WPWR-MWA-XX-XX-RP-A-0003

Planning Amendments

Vehicle Maintenance Workshop

Whaley Road

North-West
1 : 100

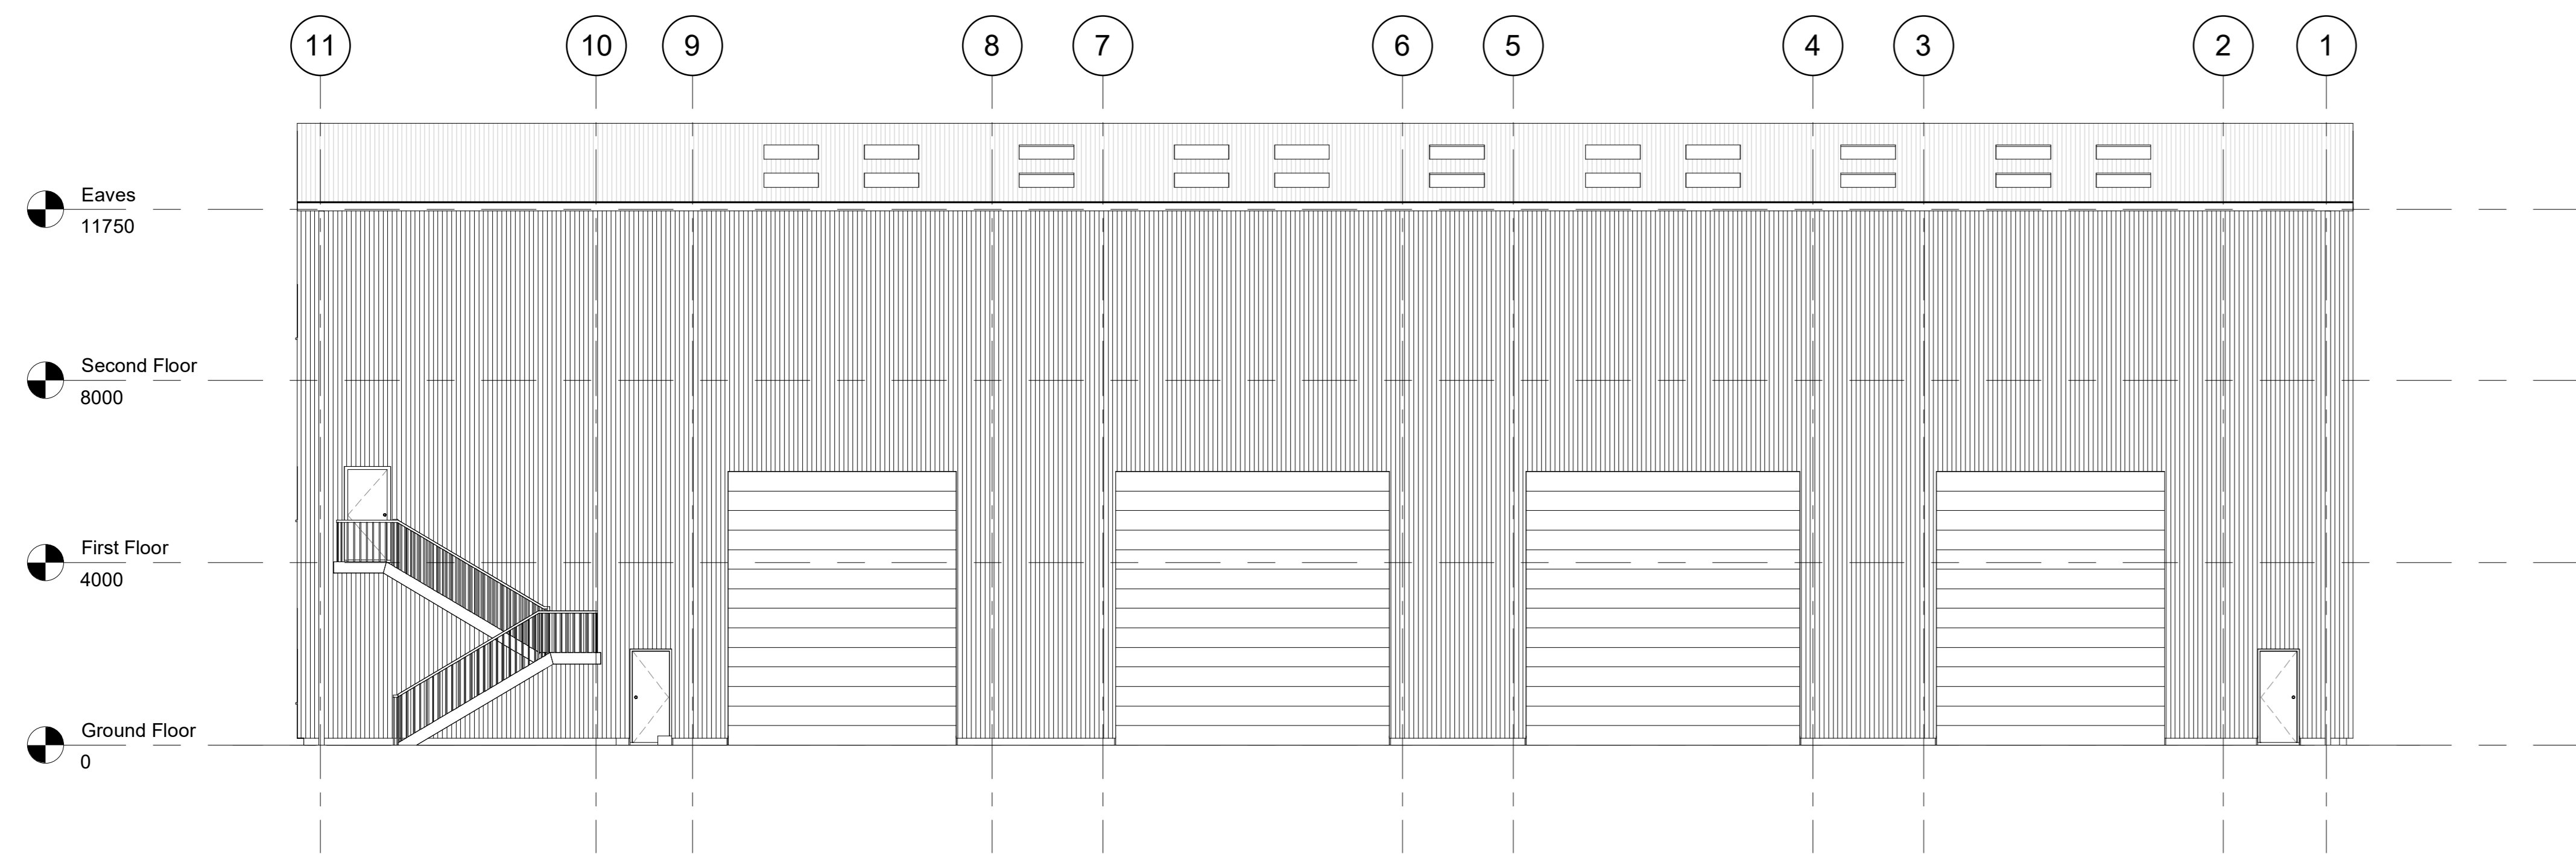
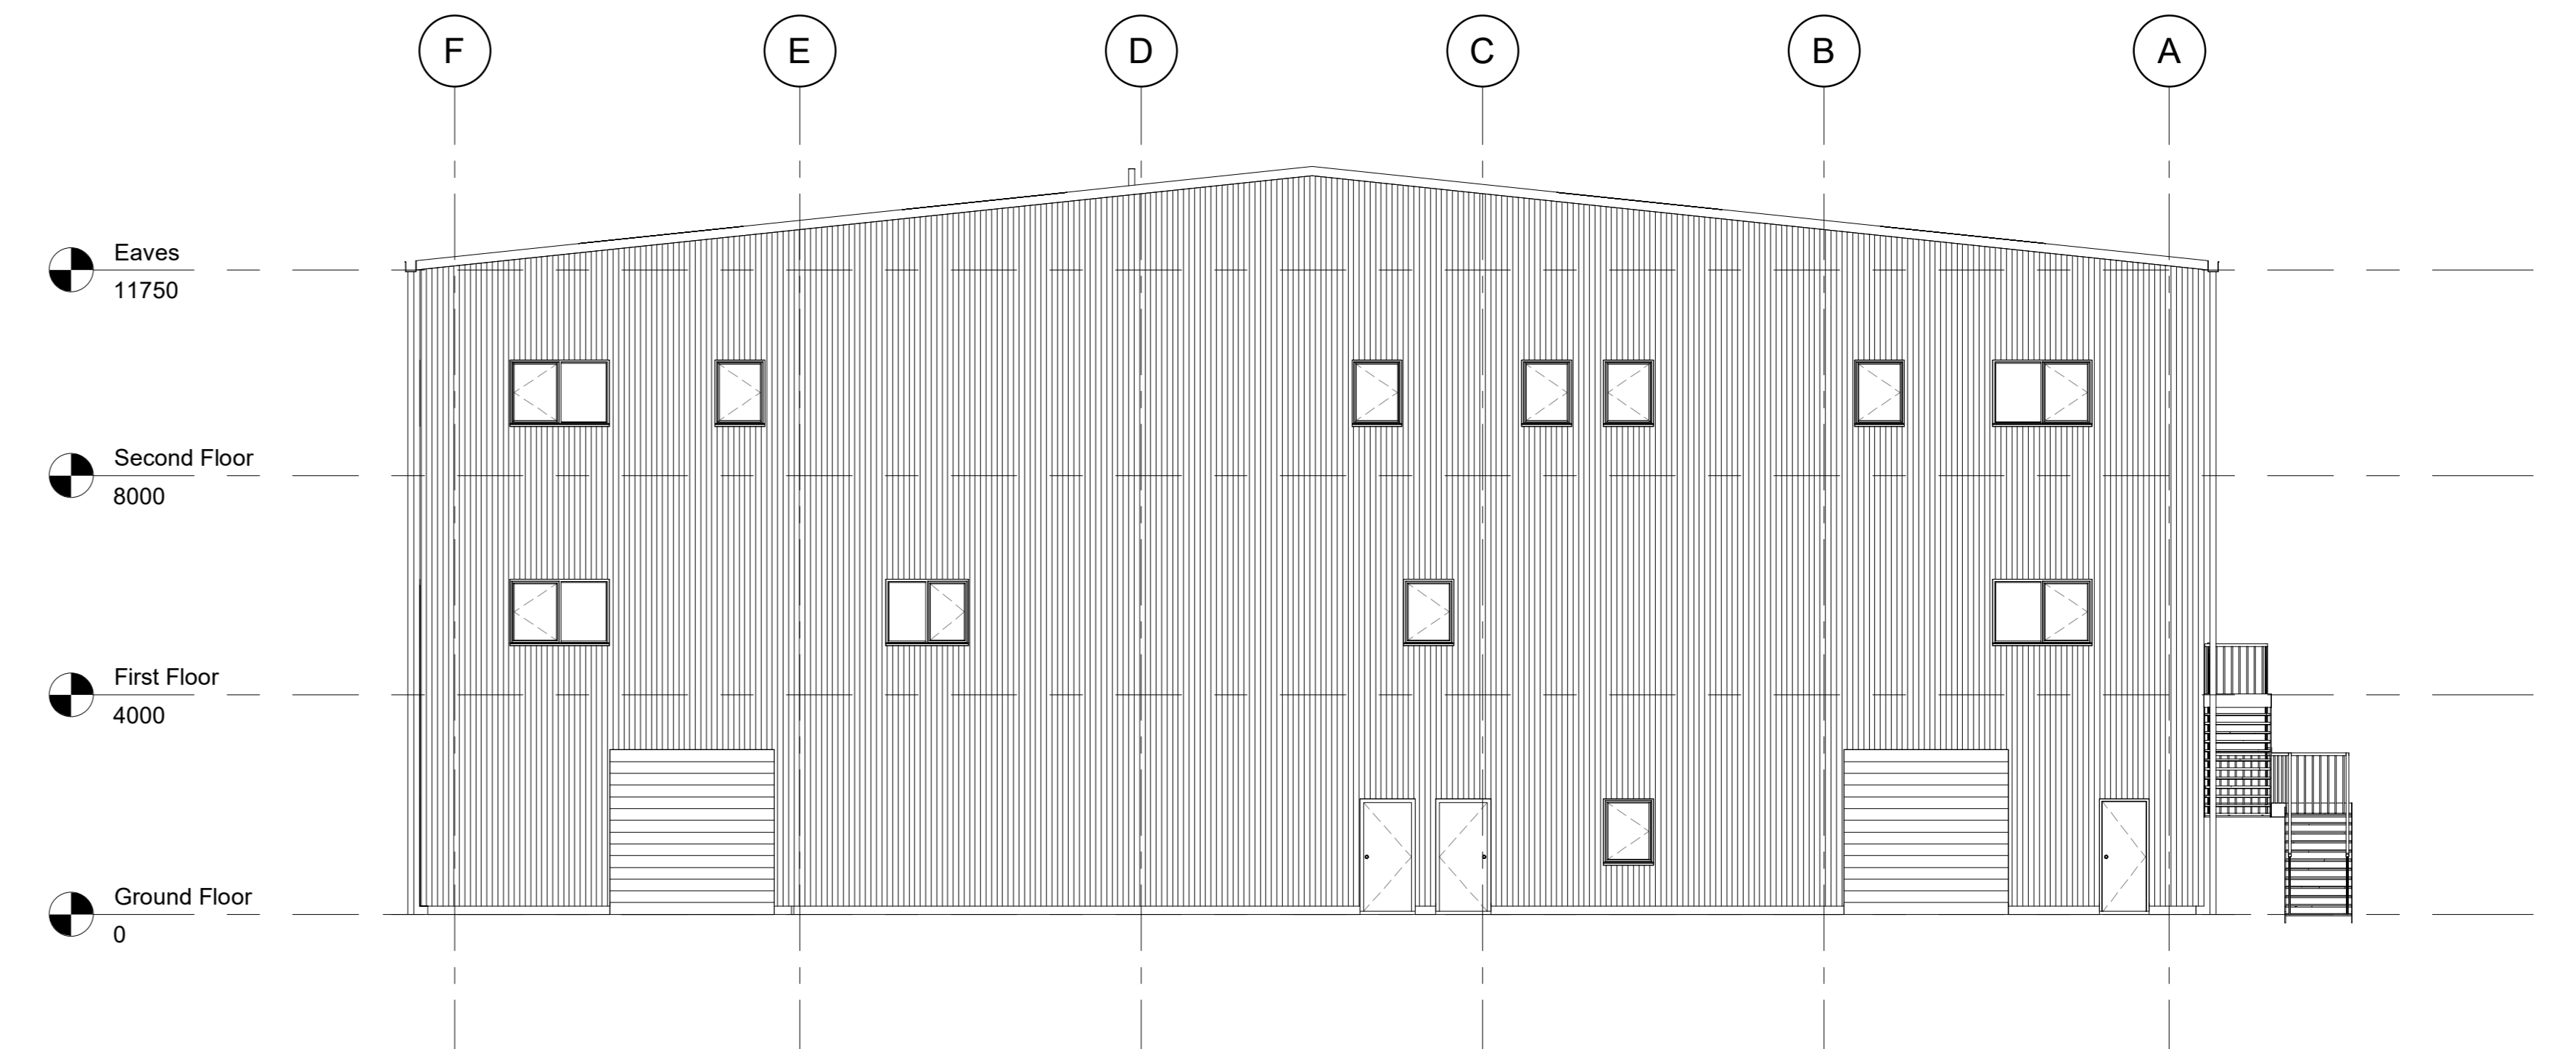
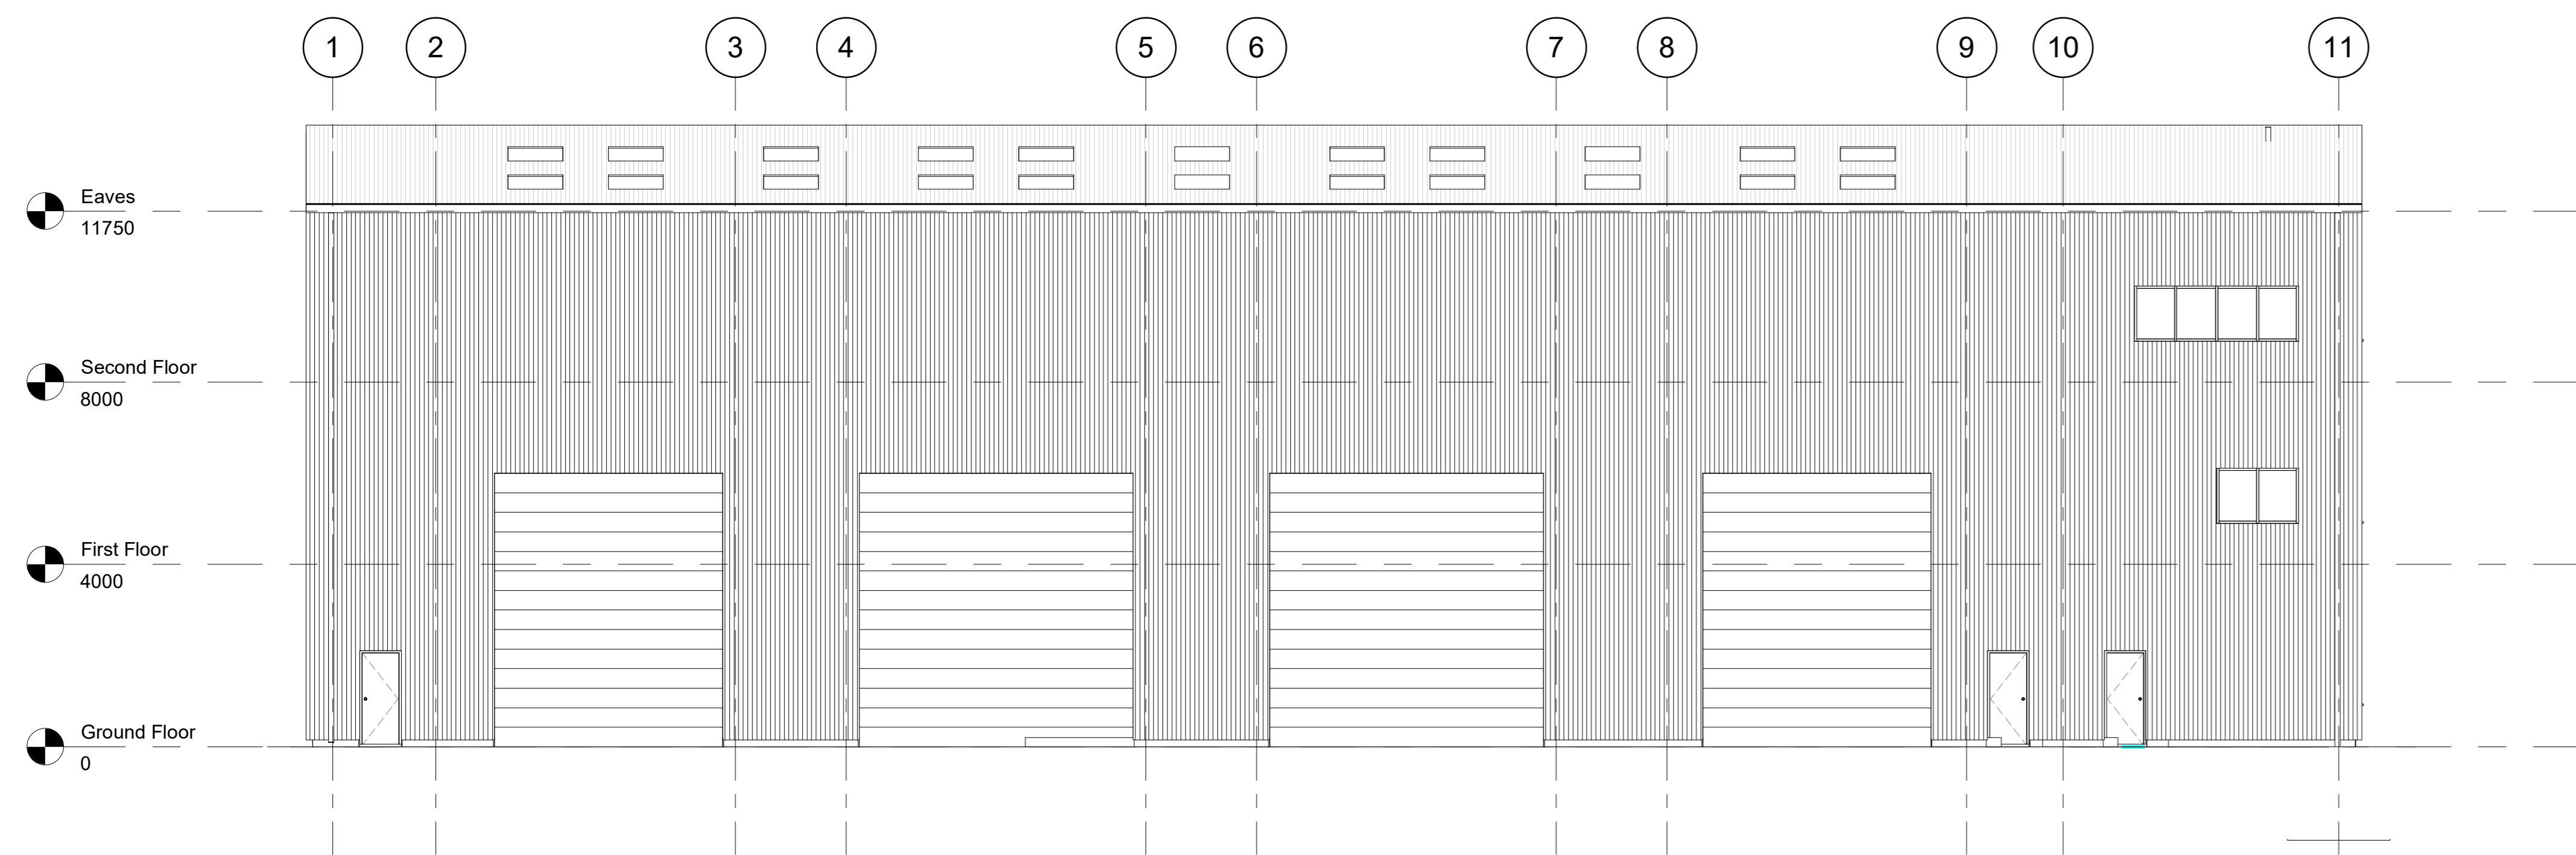
Four of the eight roller shutter doors reduced in width by 1m.

Note re solar panels added to drawings – PV will be required to meet Building Regulations energy standards

There is no change to the elevation facing the closest neighbouring site to the north-west
